Charlotte Storm Water
600 East Fourth Street
Charlotte, N C 28202-2844

Rezoning Petition Review

Rezoning Petition #: 20-121

Location of Property: Approximately 1.1 acres located along the south side of Turner Ave, the west side of Bacon Ave and south of Rozzelles Ferry Rd.

RZ-1.0

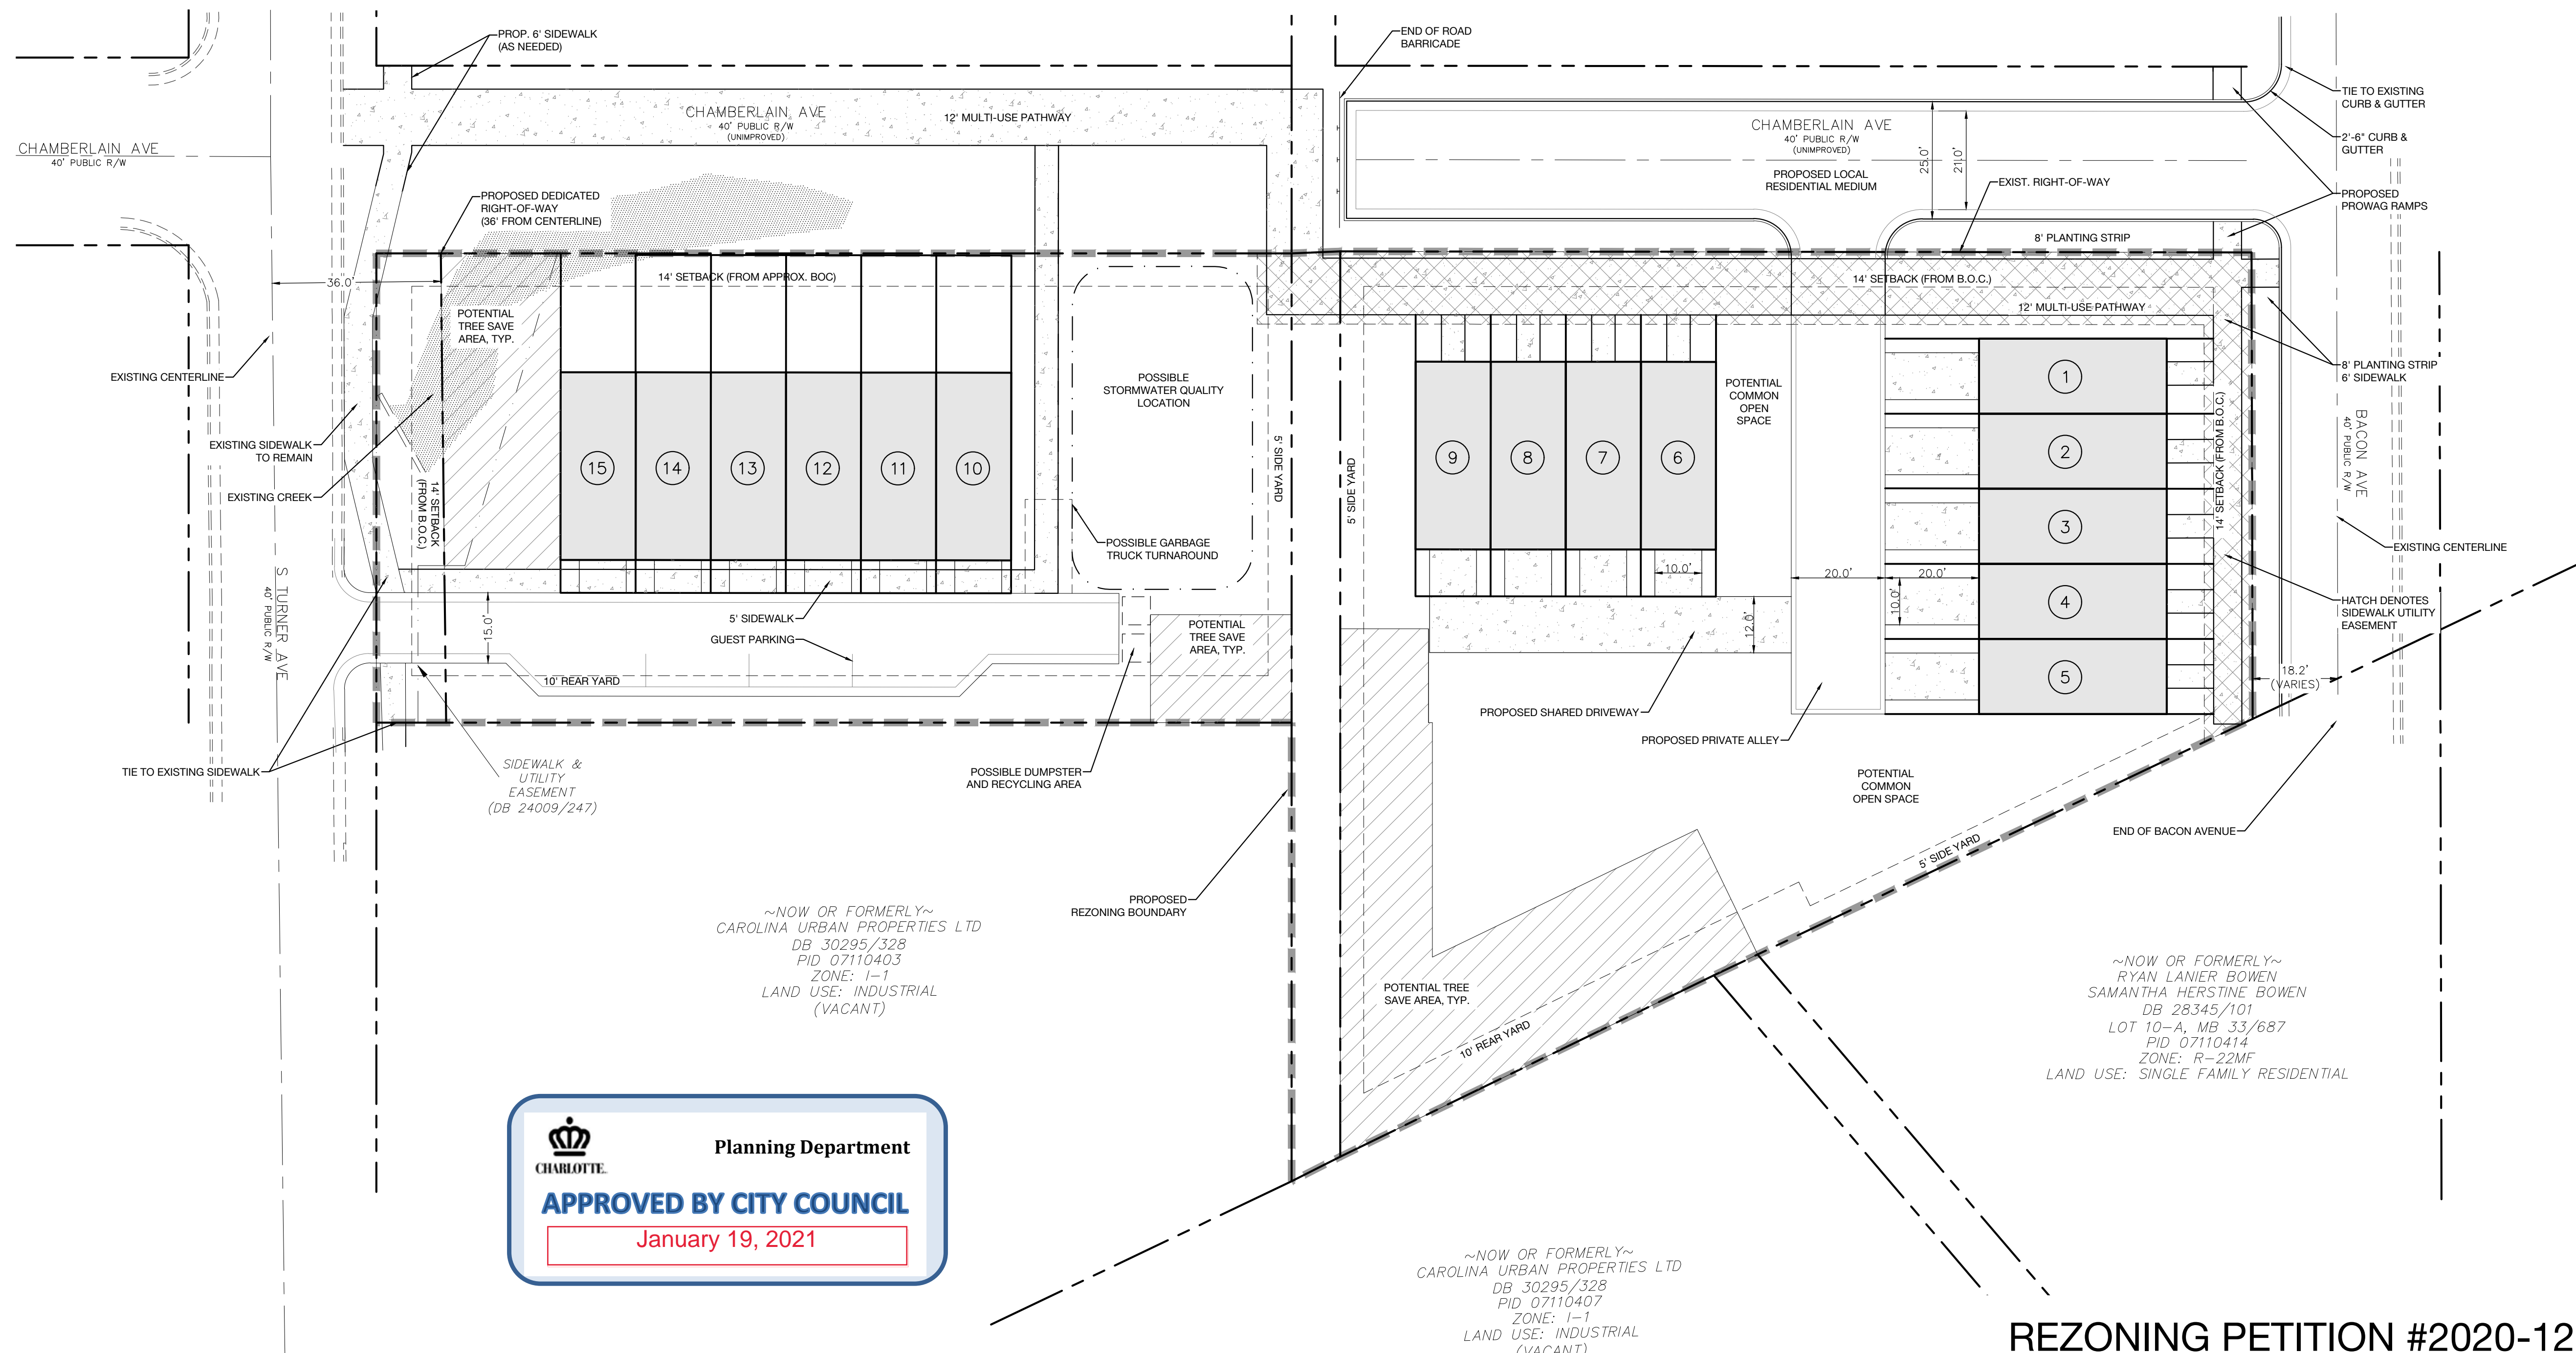
Recommendations Concerning Storm Water: Please include the following note under Environmental Features:

The location, size, and type of storm water management systems depicted on the Rezoning Plan are subject to review and approval as part of the full development plan submittal and are not implicitly approved with this rezoning. Adjustments may be necessary in order to accommodate actual storm water treatment requirements and natural site discharge points.

The rezoning site plan indicates an existing creek on site. Please be advised this may be subject to a SWIM/PCSO Buffer. Development within any SWIM/PCSO Buffer shall be coordinated with and subject to approval by Charlotte-Mecklenburg Storm Water Services and mitigated if required by City ordinance. Petitioner acknowledges intermittent/perennial stream delineation reports are subject to review and approval upon submission of development plans for permitting and are not approved with rezoning decisions.
